Appendix B - Record and Response to Public Submissions

Locomotive Street,
Australian Technology Park, Eveleigh
SSD_17 8517 Locomotive Workshop

07 June 2018 17068

4.12 Loading Dock

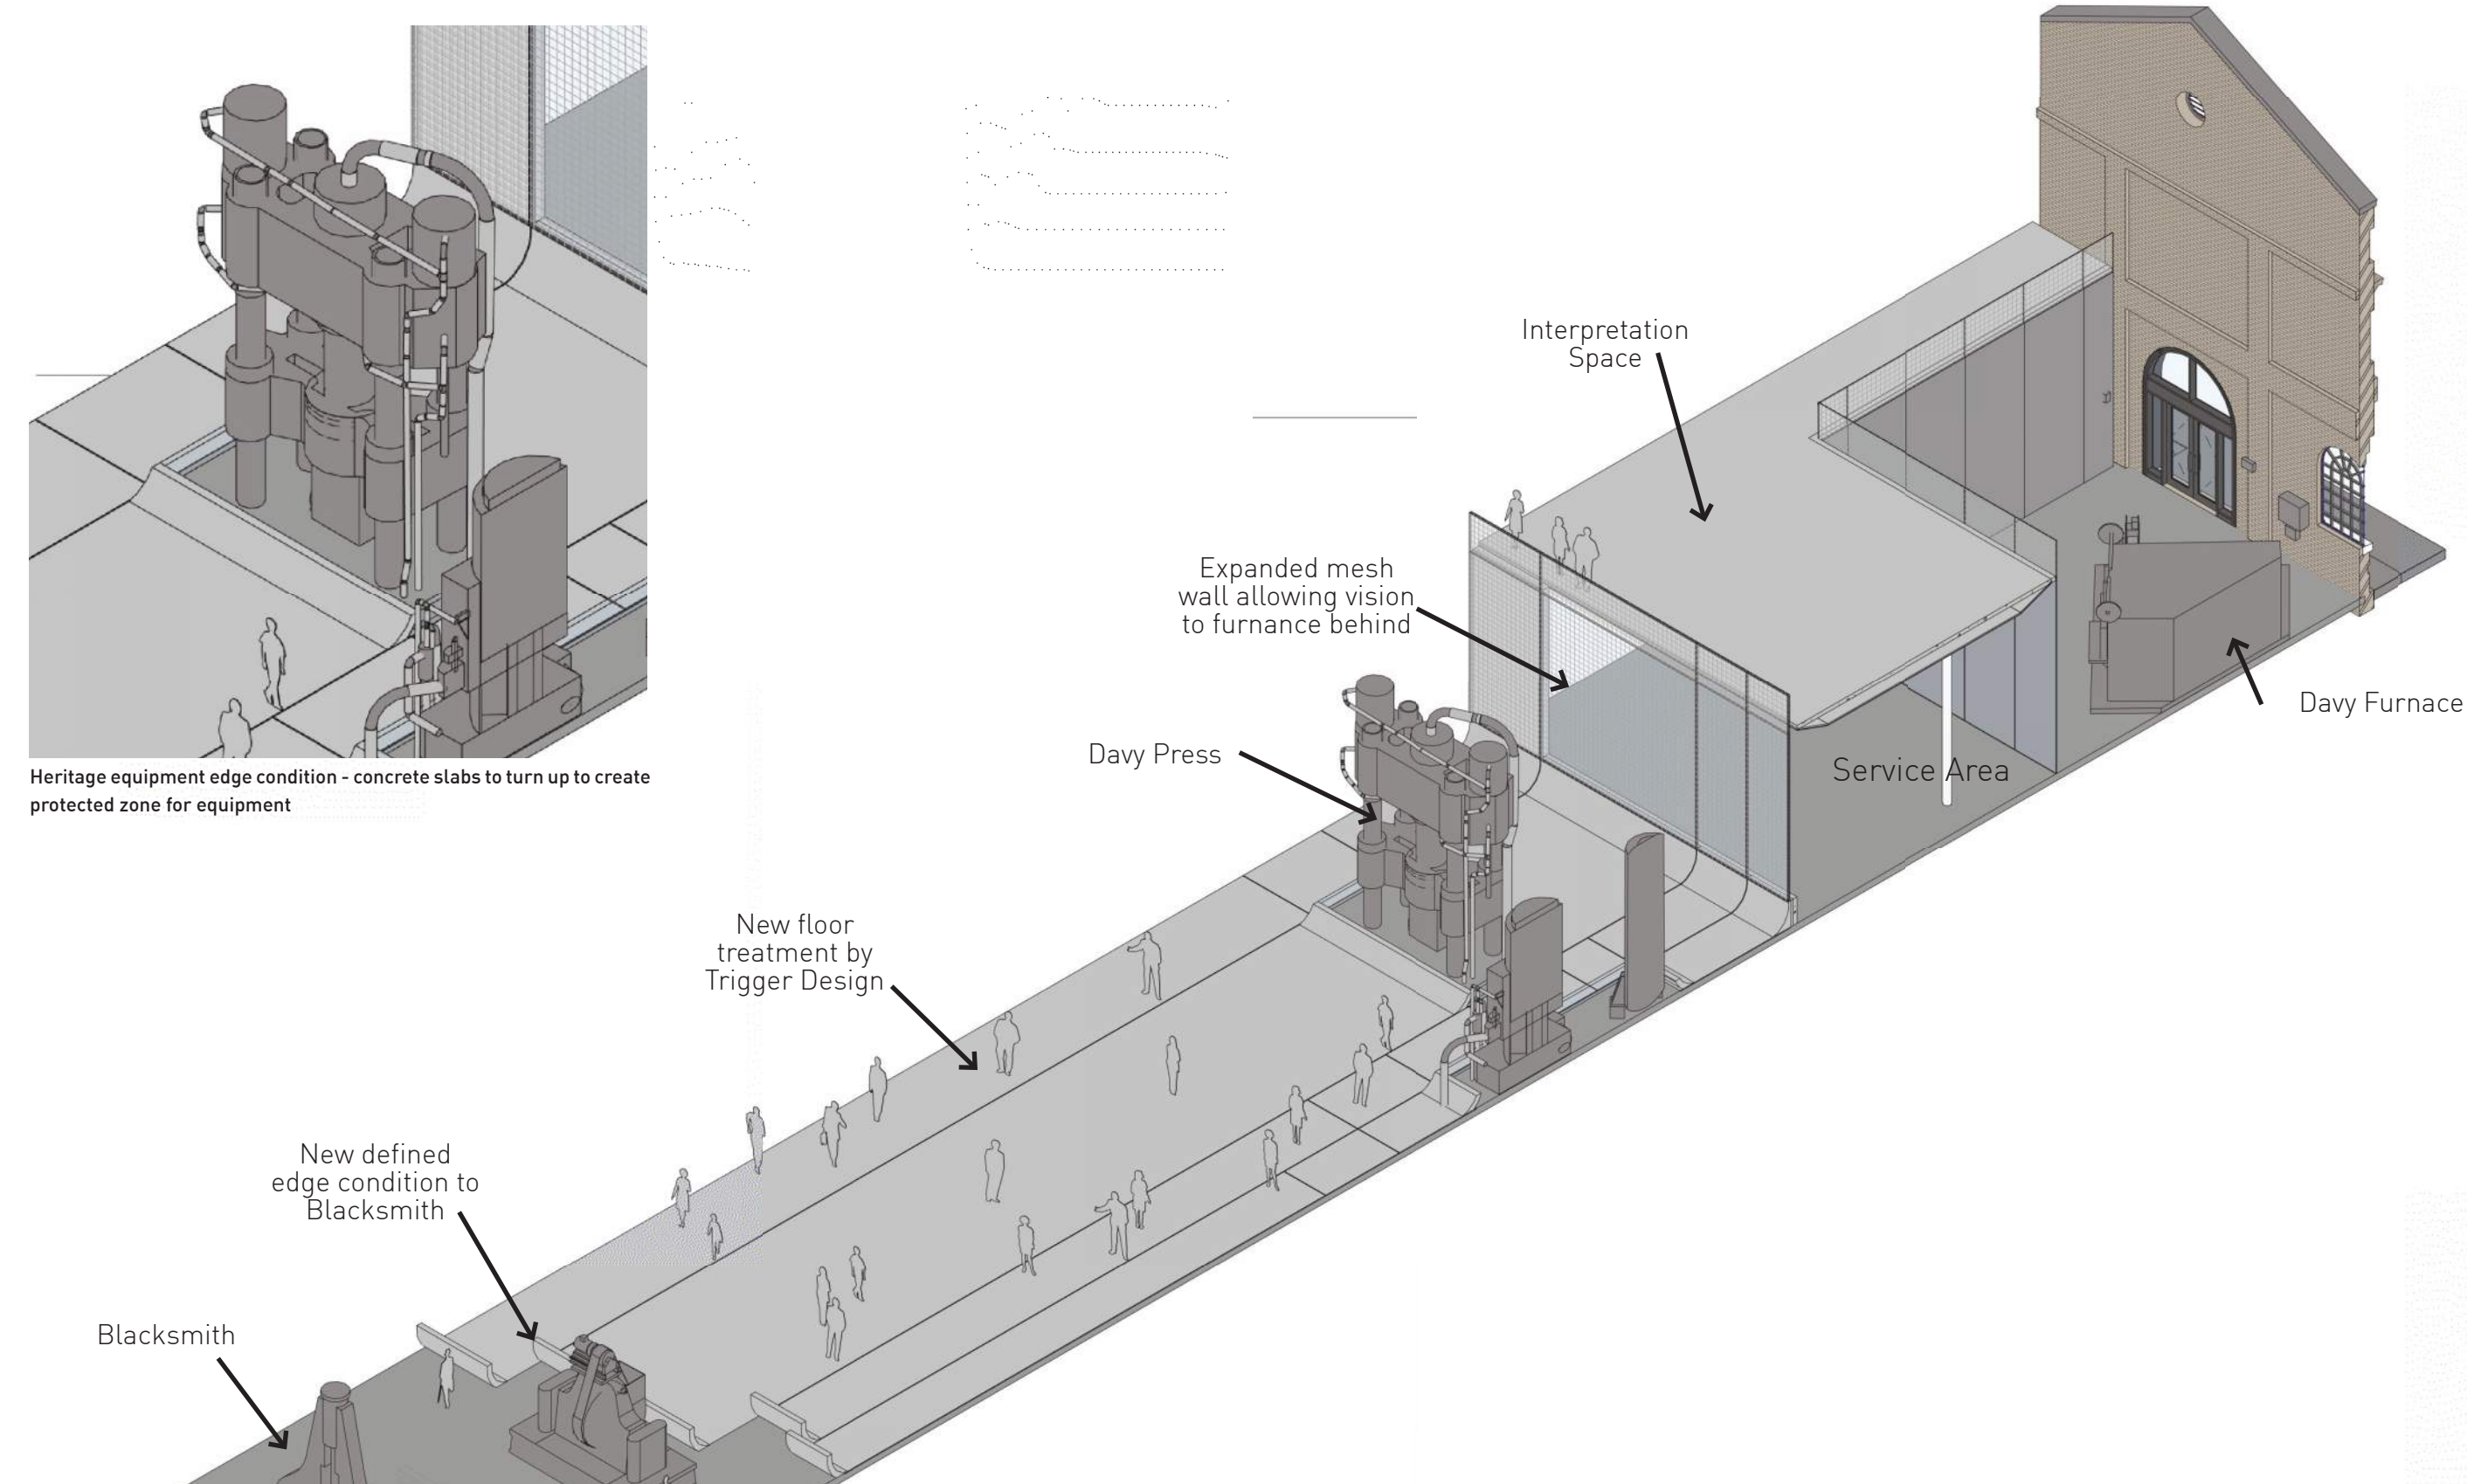
The loading dock diminishes the sense of scale and detracts from the machinery exhibits by imposing an incongruous eye saw in a sacred icon of Australian manufacturing and should not be allowed.	✓			Refer to Section 2.11 within the Heritage Response Report (Appendix E).
The insertion of a heritage interpretation booth above the loading dock is no substitute for the real thing: an intact view of "The largest steam powered Victorian blacksmithing collection known in the Western world".	✓			Refer to Section 2.11 within the Heritage Response Report (Appendix E).
The machinery collection of Bays 10, 3, 4 and 16 is under serious threat from this current proposal and provides no clear answers as to how these items could be successfully displayed and interpreted which Mirvac is currently obliged to keep and maintain.		✓		Refer to Section 2.7 within the Heritage Response Report (Appendix E).
